## Schedule of updated planning drawings and reports following amendments to facilitate Ball Strike Netting and other minor alterations

DRAWING NUMBER: 22315-ALA-00-XX-DR-L-0021

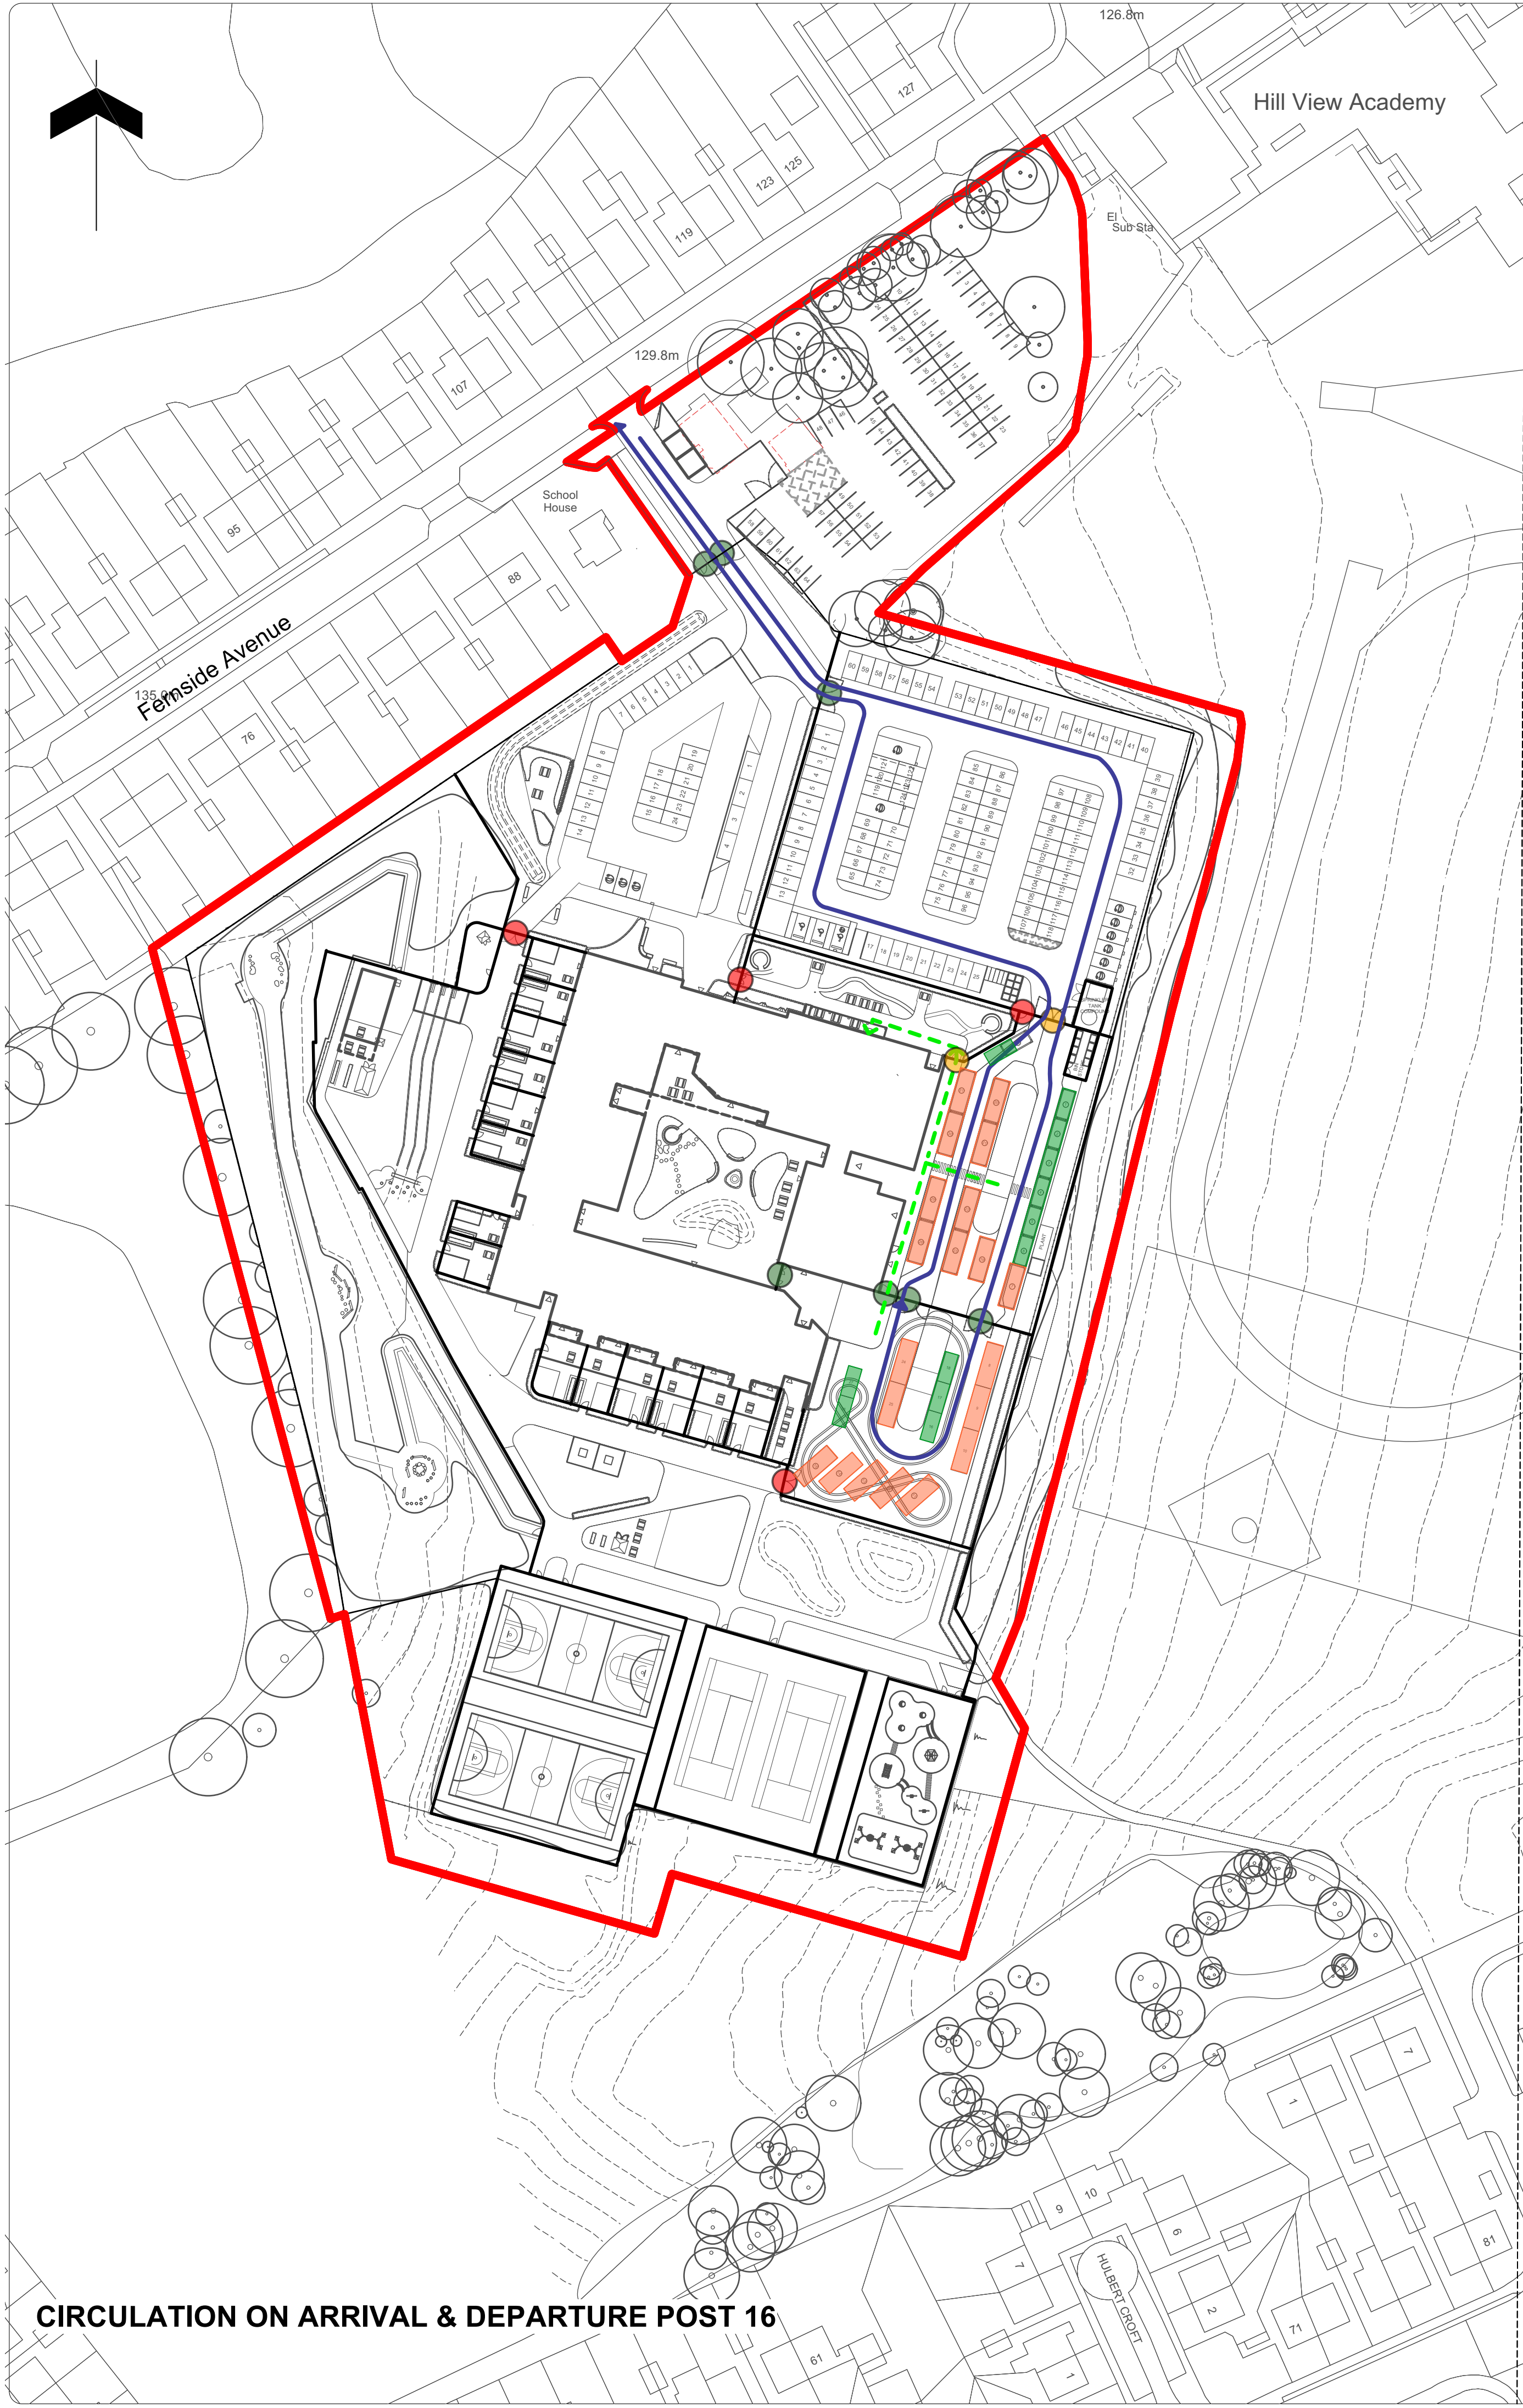
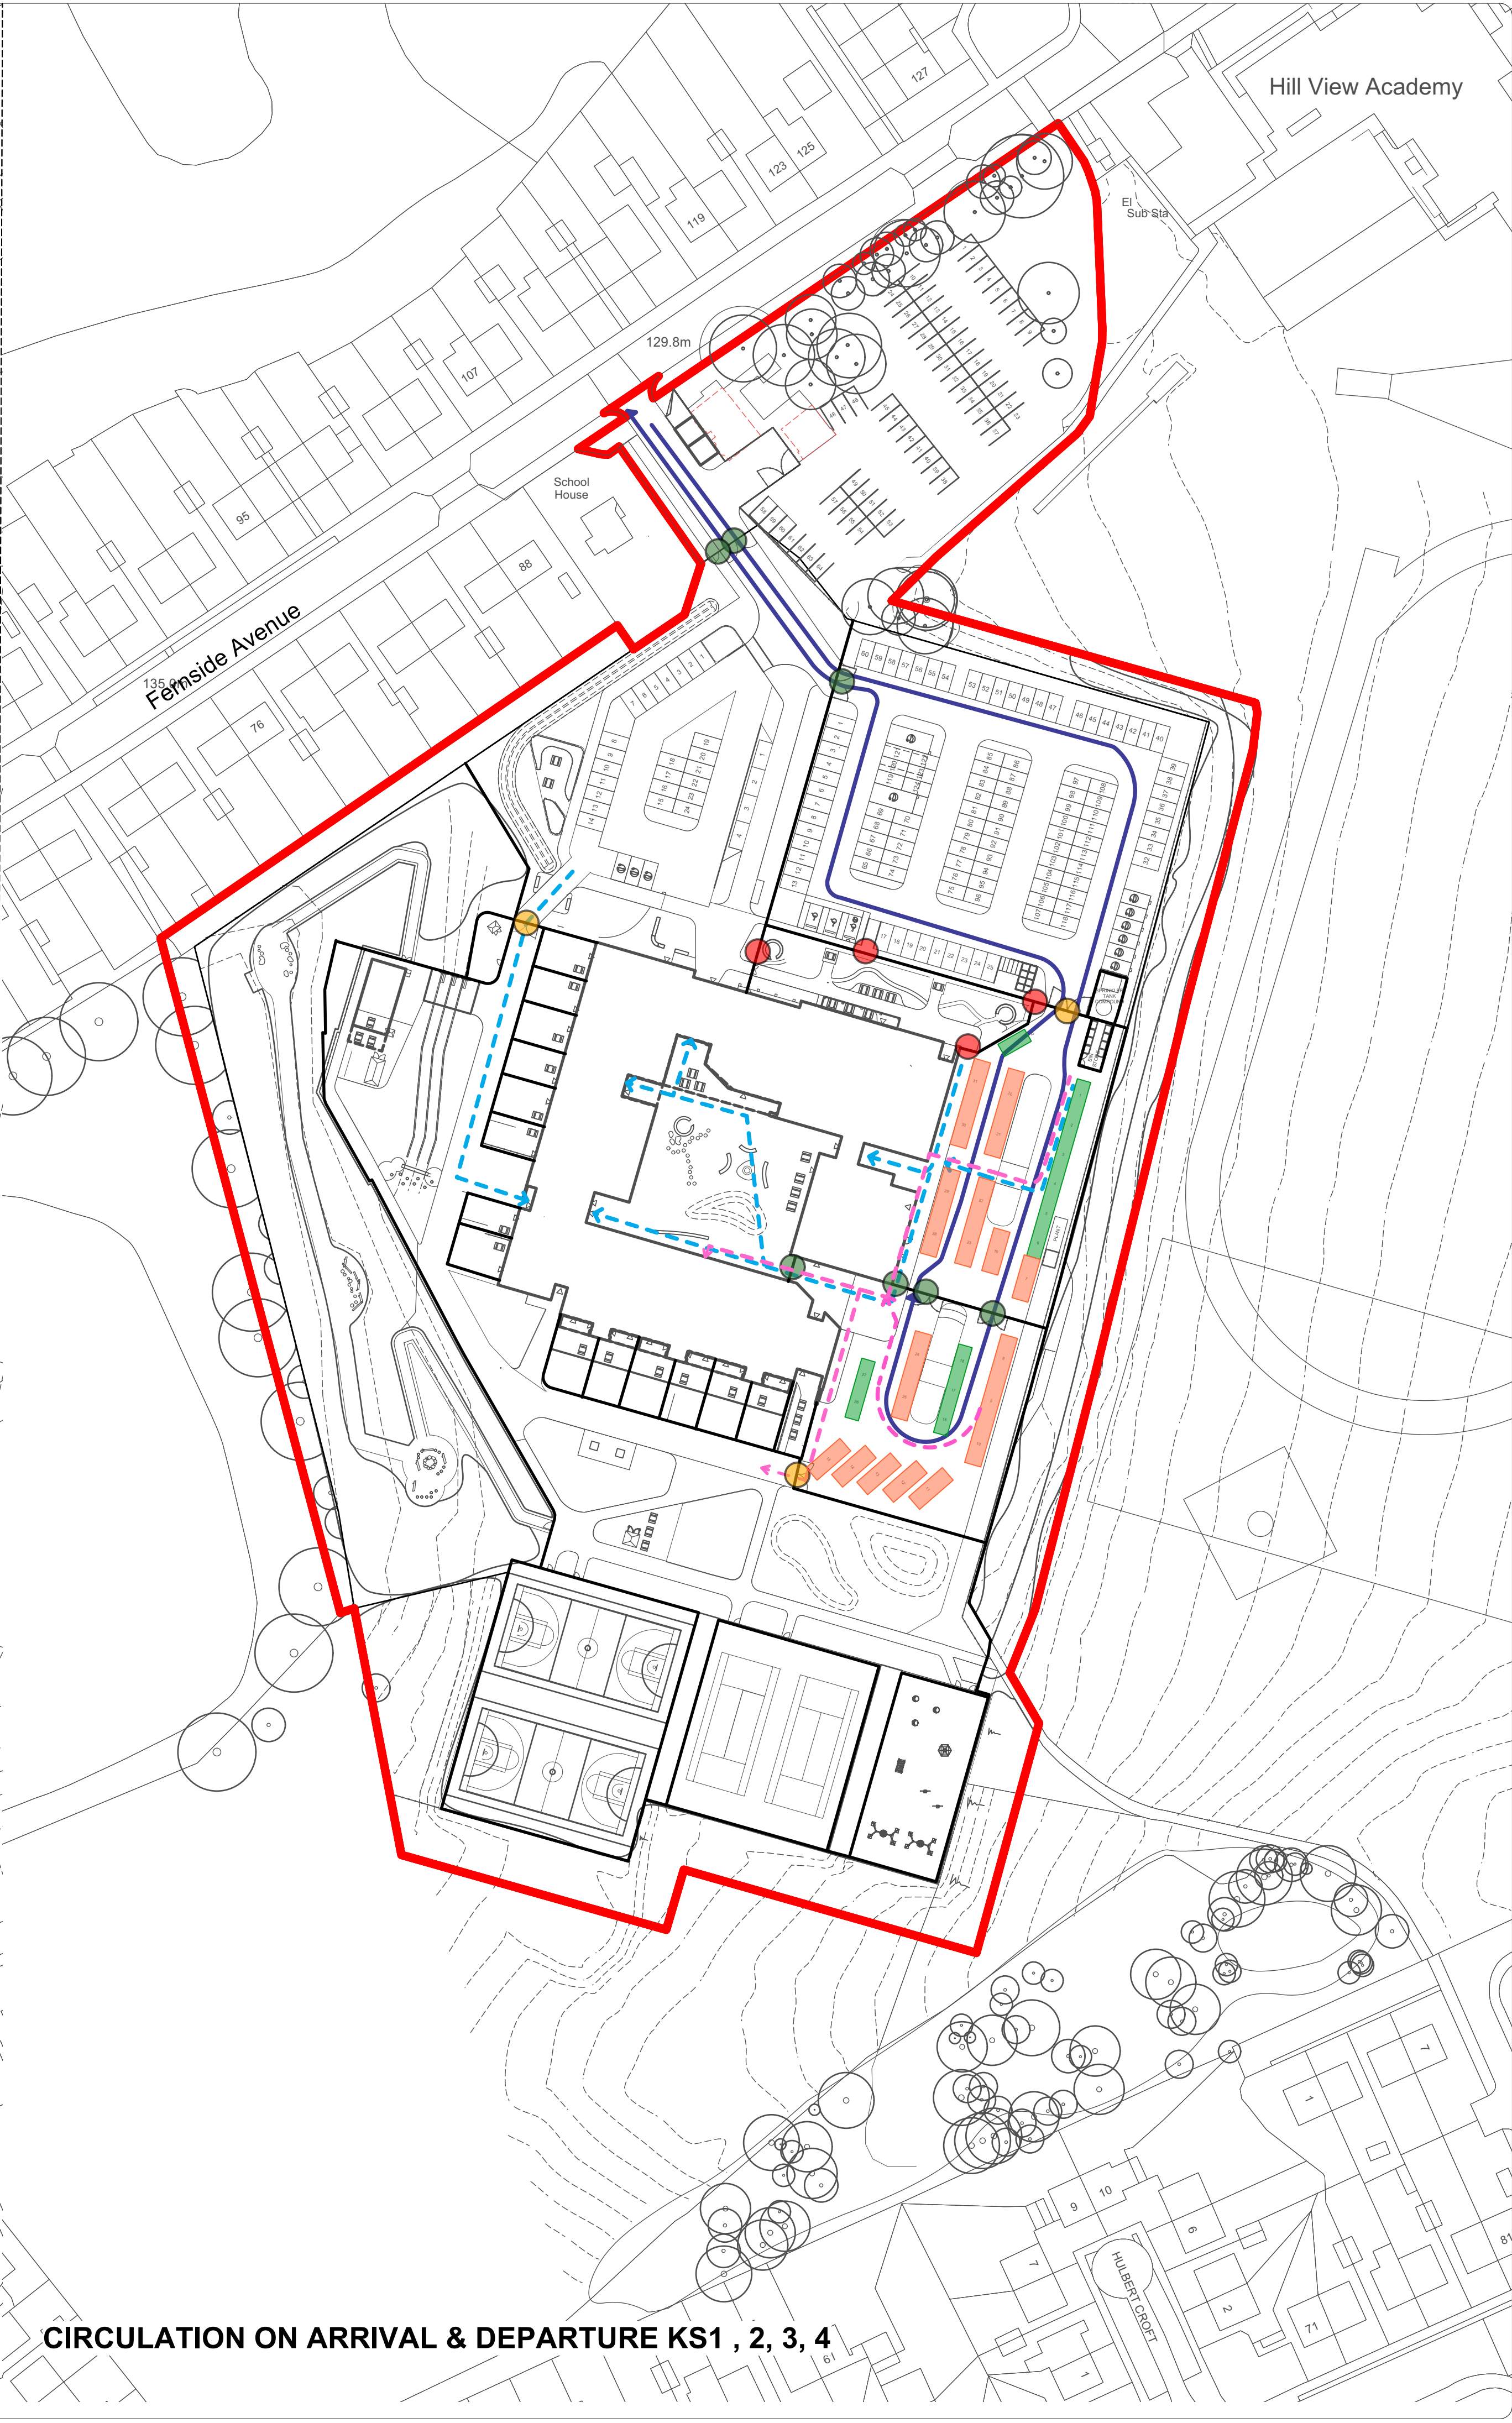
Access and Circulation Plans -Service and Maintenance -During the School Day -Arrival and Departure Students	22315-ALA-00-XX-DR-L-0010 rev. P02 22315-ALA-00-XX-DR-L-0012 rev. P02 22315-ALA-00-XX-DR-L-0021 rev. P03	22315-ALA-00-XX-DR-L-0010 rev. P04 22315-ALA-00-XX-DR-L-0012 rev. P04 22315-ALA-00-XX-DR-L-0021 rev. P05	Re-issued for planning following Sport England objection withdrawal. Changes as follows: 1. Updated to align with changes to GA. 2. Vehicle entrance barrier indicated on diagram.
EVCP Provision Plan	22315-ALA-00-XX-DR-L-0033 rev. P01	22315-ALA-00-XX-DR-L-0033 rev. P06	Re-issued for planning following Sport England objection withdrawal. Changes as follows: 1. Updated to align with changes to GA.
Waste Management Plan	22315-ALA-00-XX-DR-L-0034 rev. P01	22315-ALA-00-XX-DR-L-0034 rev. P06	Re-issued for planning following Sport England objection withdrawal. Changes as follows: 1. Updated to align with changes to GA.

Plan	Reference	Updated drawing	Description of amendments
			2.Binstore layout revised.
Urban Green Space	22315-ALA-00-XX-DR-L-0035 rev. P01	22315-ALA-00-XX-DR-L-0035 rev. P03	Re-issued for planning following Sport England objection withdrawal. Changes as follows: 1.Updated to align with changes to GA.
Sequential Axonometric	WSC-FSA-XX-XX-DR-A-7010 rev. P05	No revision	No revision
Street Scene Plan	WSC-FSA-XX-XX-DR-A-7020	No revision	No revision
Proposed Drainage Layout	22315-BWB-XX-XX-D-C-0500 rev. P03	No revision	No revision
External Lighting Plan	22315-AGL-24-XX-D-E-0001 rev. P06	No revision	No revision
Planning and Legal Completion Boundary Plan	22315-ALA-00-XX-DR-L-0038 P01	No revision	No revision
Ball Stop Netting Layout	22315-ALA-00-XX-DR-L-0049_P02	(previously submitted on 23.01.25)	Details of proposed ball stop netting to meet Sports England requirement
<b>New Plan</b> - Ball Stop Netting Detail	n/a	22315-ALA-ZZ-ZZ-D-L-1034_P03	Details of proposed ball stop netting to meet Sports England requirement

DRAWING NUMBER: 22315-ALA-00-XX-DR-L-0001
STATUS: S2
REVISION: P17

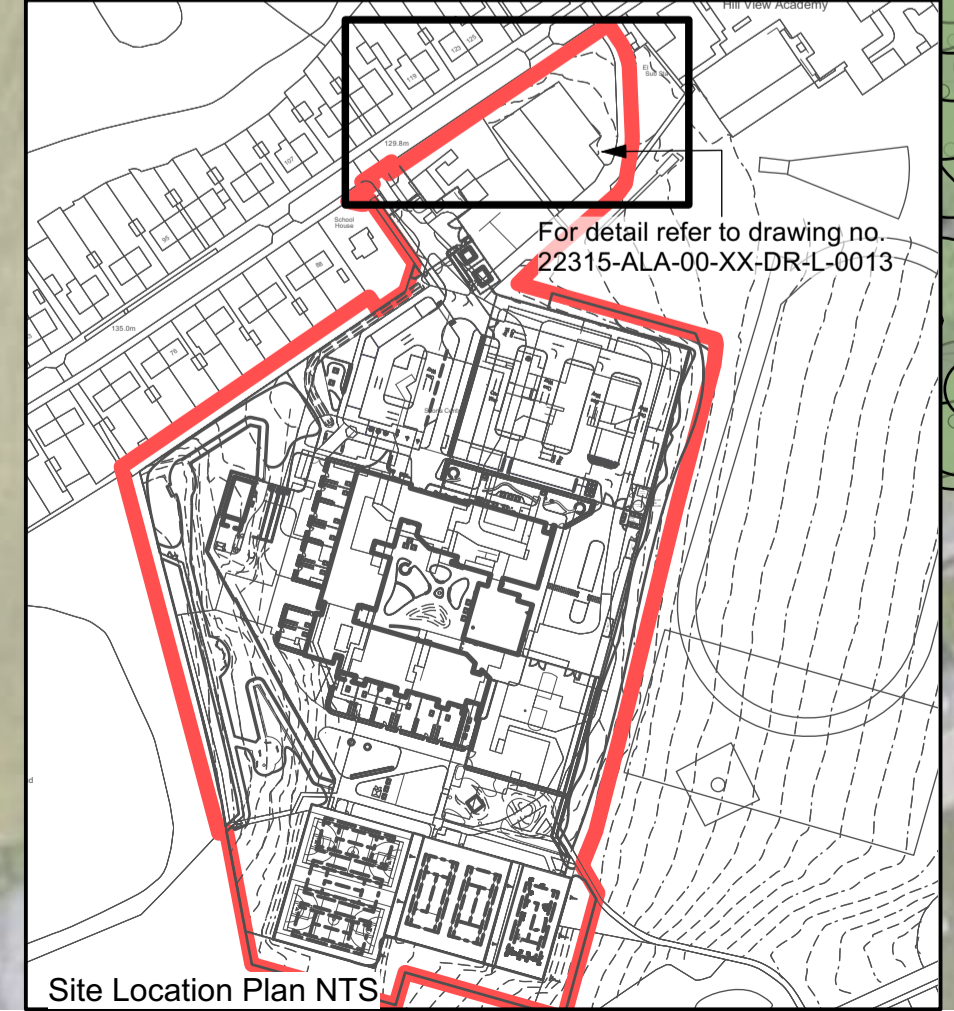
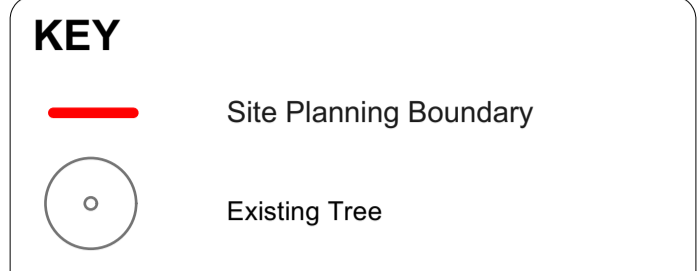
22315-ALA-00-XX-DR-L-0022 rev. P04	22315-ALA-00-XX-DR-L-0022 rev. P09	
	22315-ALA-00-XX-DR-L-0024 rev. P03	22315-ALA-00-XX-DR-L-0024 rev. P08	
	22315-ALA-00-XX-DR-L-0037 rev. P03	22315-ALA-00-XX-DR-L-0037 rev. P08	
Landscape Illustrative Masterplan	22315-ALA-00-XX-DR-L-0001 rev. P13	22315-ALA-00-XX-DR-L-0001 rev. P17	Re-issued for planning following Sport England objection withdrawal. Changes as follows: 1. Ball Stop netting added, hedge removed, and Forest School area updated. 2. Substation relocated and pedestrian entrance route. 3. Terracing and slide to Forest School amended.

Plan	Reference	Updated drawing	Description of amendments
			<p>4. Play item locations adjusted to account for critical fall distances.</p> <p>5. Reinforced grass proposed to start and finish of natural play features.</p> <p>6. Horticulture area adjusted to latest Forest School Cabin layout, with 2no. Play Stores added.</p> <p>7. Swale length adjusted to avoid conflict with adjacent paving.</p> <p>8. Entrance sign proposed.</p> <p>9. Play mound levels amended, with play furniture rearranged to suit.</p> <p>10. N note amended to remove reference to relocated Forest School Cabin.</p>
Landscape General Arrangement	22315-ALA-00-XX-DR-L-0002 rev. P03	22315-ALA-00-XX-DR-L-0002 rev. P11	<p>Re-issued for planning following Sport England objection withdrawal. Changes as follows:</p> <p>1. Ball Stop netting added, hedge removed, and Forest School area updated.</p> <p>2. Substation relocated and pedestrian entrance route.</p> <p>3. Terracing and slide to Forest School amended.</p> <p>4. Play item locations adjusted to account for critical fall distances.</p> <p>5. Reinforced grass proposed to start and finish of natural play features.</p> <p>6. Horticulture area adjusted to latest Forest School Cabin layout, with 2no. Play Stores added.</p> <p>7. Swale length adjusted to avoid conflict with adjacent paving.</p> <p>8. Entrance sign proposed.</p> <p>9. Play mound levels amended, with play furniture rearranged to suit.</p>

Wider Landscape General Arrangement	22315-ALA-00-XX-DR-L-0005 rev. P03	22315-ALA-00-XX-DR-L-0005 rev. P09	<p>Re-issued for planning following Sport England objection withdrawal. Changes as follows:</p>

Plan	Reference	Updated drawing	Description of amendments
			<ol style="list-style-type: none"> <li>1. Ball Stop netting added, hedge removed, and Forest School area updated.</li> <li>2. Substation relocated and pedestrian entrance route.</li> <li>3. Terracing and slide to Forest School amended.</li> <li>4. Play item locations adjusted to account for critical fall distances.</li> <li>5. Reinforced grass proposed to start and finish of natural play features.</li> <li>6. Horticulture area adjusted to latest Forest School Cabin layout, with 2no. Play Stores added.</li> <li>7. Swale length adjusted to avoid conflict with adjacent paving.</li> <li>8. Entrance sign proposed.</li> <li>9. Play mound levels amended, with play furniture rearranged to suit.</li> </ol>
Wider Landscape Illustrative Masterplan	22315-ALA-00-XX-DR-L-0013 rev. P04	22315-ALA-00-XX-DR-L-0013 rev. P10	<p>Re-issued for planning following Sport England objection withdrawal. Changes as follows:</p> <ol style="list-style-type: none"> <li>1. Ball Stop netting added, hedge removed, and Forest School area updated.</li> <li>2. Substation relocated and pedestrian entrance route.</li> <li>3. Terracing and slide to Forest School amended.</li> <li>4. Play item locations adjusted to account for critical fall distances.</li> <li>5. Reinforced grass proposed to start and finish of natural play features.</li> <li>6. Horticulture area adjusted to latest Forest School Cabin layout, with 2no. Play Stores added.</li> <li>7. Swale length adjusted to avoid conflict with adjacent paving.</li> <li>8. Entrance sign proposed.</li> <li>9. Play mound levels amended, with play furniture rearranged to suit.</li> </ol>
